**Dogger Bank South Offshore
Wind Farms**

**The Applicants' Response to the Marine
Management Organisation's Deadline 9
Document**

Document Reference: 20.2

Figure: 2.1	Drawing No:	
Co-ordinate system: WGS 1984 UTM Zone 30N	Page Size: A3	Scale: 1:850,000
Project:  Dogger Bank South Offshore Wind Farms	Report:

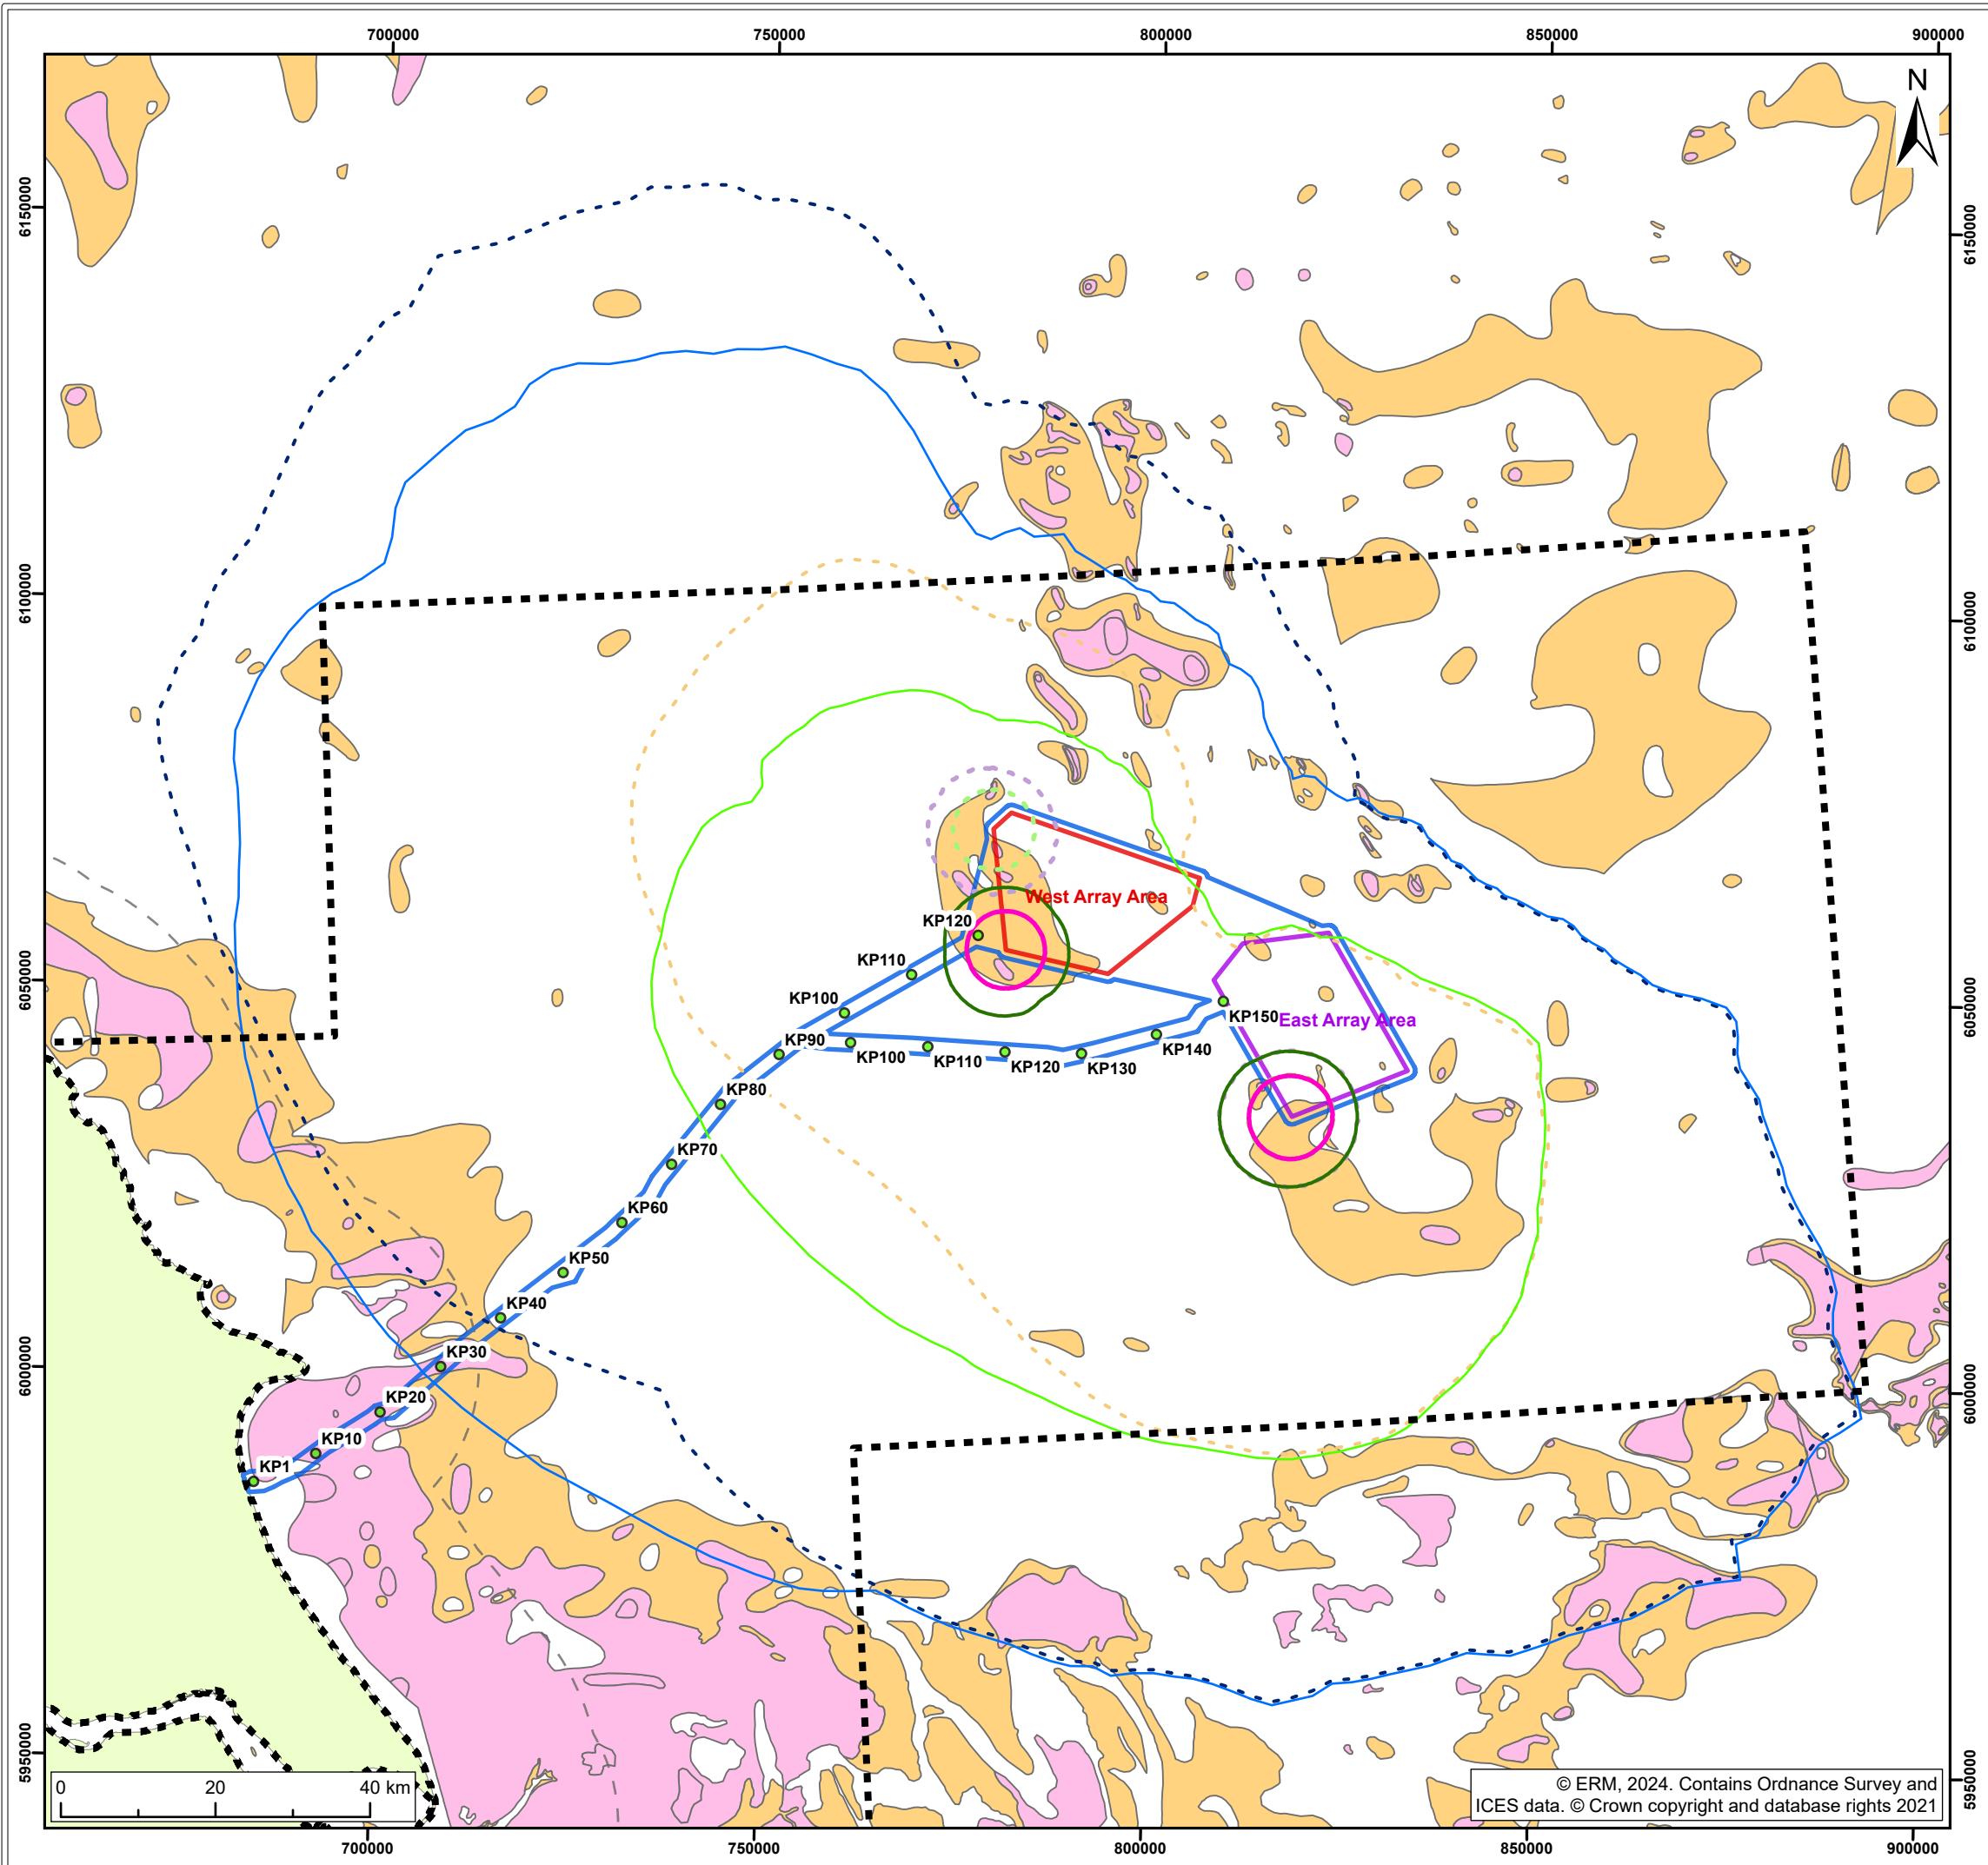
1.2.5	As per Figure 2.1 in REP5-042 (Modelling of underwater noise associated with alternative piling locations to inform potential impacts on Atlantic herring spawning grounds) this shows the worst case scenario with unmitigated piles. Figure 2.2 showed the 'Extent of preferred and marginal potential spawning habitat for Atlantic herring in the vicinity of the Dogger Bank South Offshore Windfarms overlaid with contours associated with revised and original monopiling locations'. The Noise Restriction Boundary line does not sit along the border of the preferred and marginal potential spawning habitat. The use of the terms 'preferred' and 'marginal' only refers to the types of sediment that herring spawning on (e.g. gravel & sandy gravel = preferred, gravelly sand = marginal). To be clear, the maps are 'heat' maps comprised of several layers of data including IHLS data and sediment (PSA data). Each data layer is associated with a scoring method, and when the scores of each data layer are combined, an overall 'confidence' score can be given. This gives some areas higher or lower scores, which broadly equate to the different 'heat' colours of the map. So, the heat maps show high (red) confidence in spawning near Flamborough Head, and high to medium confidence (peach) for much of the offshore area, with small patches of low (blue) confidence further out. The Herring Spawning plan shows the Herring Spawning Noise Restriction Boundary along the border the habitat identified within Figure 2.2. Effectively the Applicant has drawn a boundary when there is no evidence linking this boundary to the impact pathway for UWN from piling.	The Herring Spawning Noise Restriction Boundary shown on the ' Without Prejudice' Herring Spawning Plan (Revision 2) [REP9-020] has been included where both confidence is identified as 'higher' (<0.05), and where sediment is considered to be either preferred or marginal. In areas where only one or neither of these conditions are met, the likelihood of herring spawning occurring is greatly reduced. The region of medium (peach) confidence indicated is a result of the presence of the International Herring Larvae Survey (IHLS) (general) data layer, which is a polygon surrounding all IHLS sampling locations that have sampled larvae. Whilst this data layer contributes to greater overall confidence, it is not considered reasonable to attribute the presence of this data layer to meaningfully increase the likelihood of herring spawning occurring beyond that of the low (blue) confidence regions further offshore. Therefore, the Herring Spawning Noise Restriction Boundary shown on the ' Without Prejudice' Herring Spawning Plan (Revision 2) [REP9-020] has been drawn along what is considered a realistic, evidence led, boundary dividing a distinct region of higher and lower potential for herring spawning. If the precautionary 135dB behaviour threshold contour (based on underwater noise modelling of the final project design), is seaward of the proposed Herring Spawning Noise Restriction Boundary this will result in a minimum distance of 38km between the coast and the 135dB contour, this distance increases rapidly to both the north and south of Flamborough Head. After continued engagement during the ExA's recommendation period, the MMO / Cefas confirmed via email on the 24 th September 2025 that they were content with a 38km migratory corridor (shown in Appendix A) at the shortest distance and the location of the Herring Spawning Noise Restriction

Cable Installation Works Restricted Area Plan

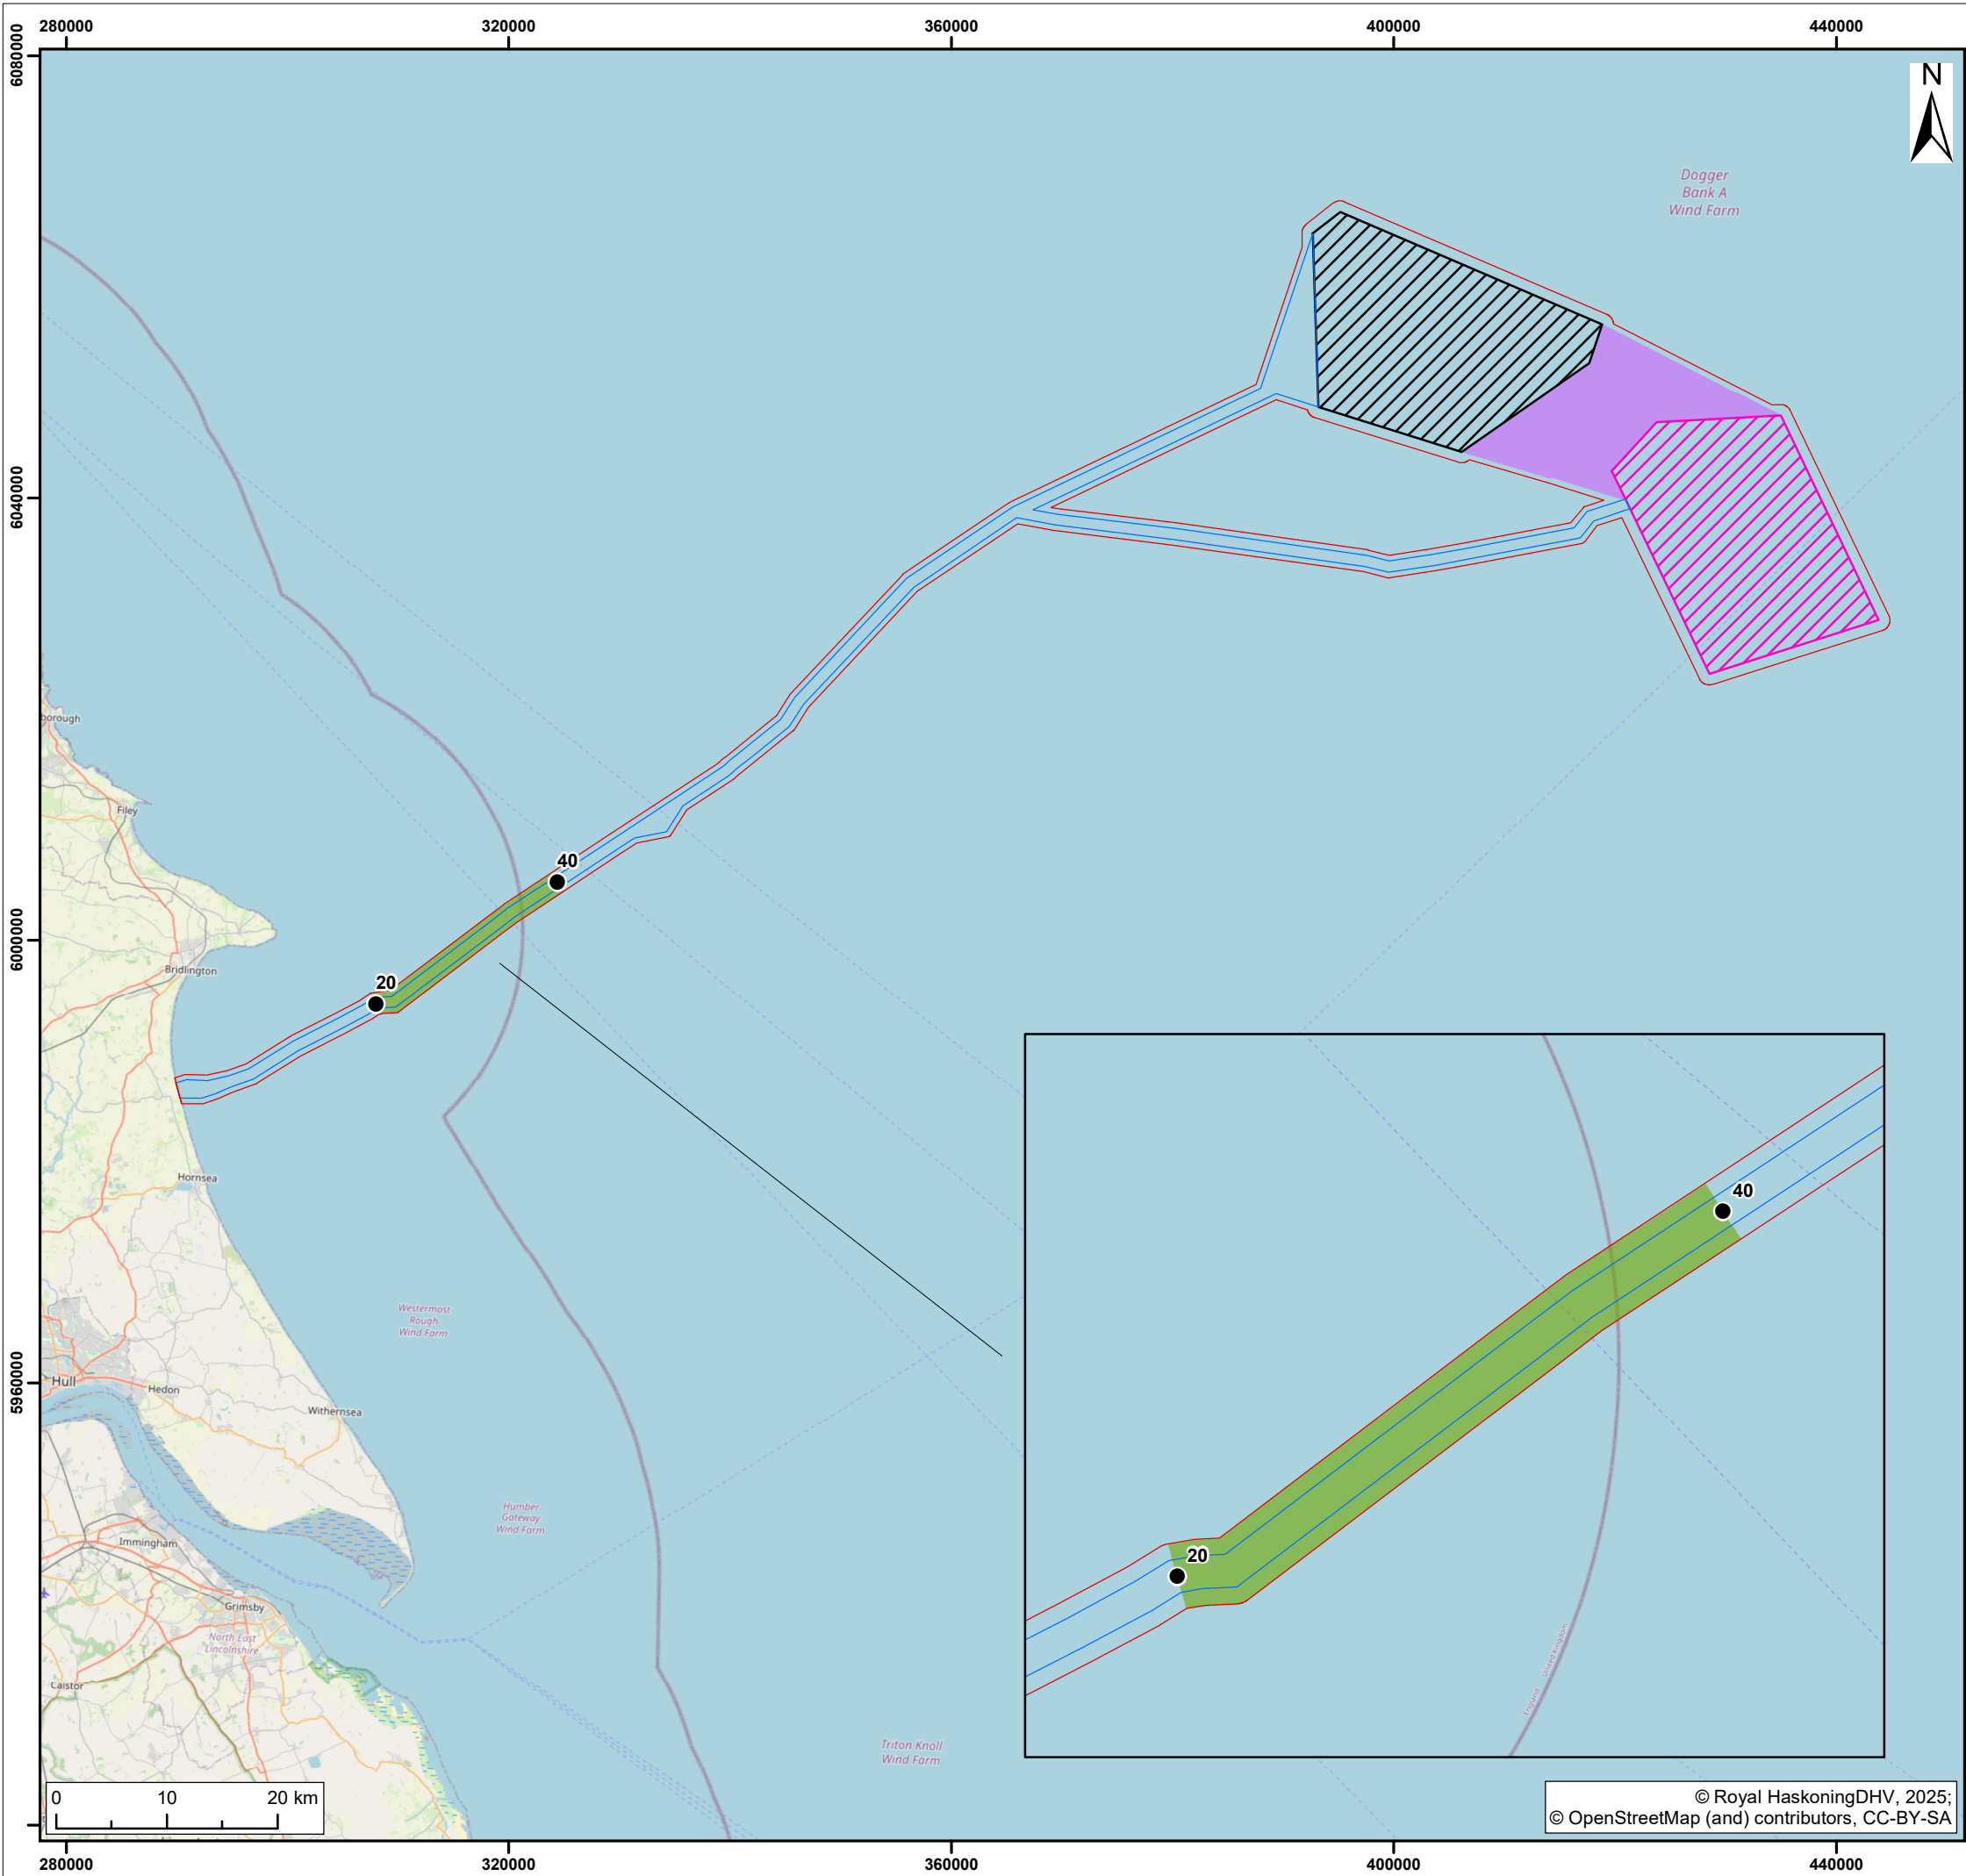
1.3.1	1.3 Closing statement on the Herring restriction for cable corridor This matter is relating to the cable works within the herring spawning habitat and the disturbance and loss of the habitat. For the avoidance of doubt the Applicant has provided further information and the MMO is content the only impacted area for disturbance is between KP20-KP40. The MMO is also content with REP8-045 - 18.5 Cable Installation Works Restricted Area Plan.	The Applicants welcome the MMO's agreement.
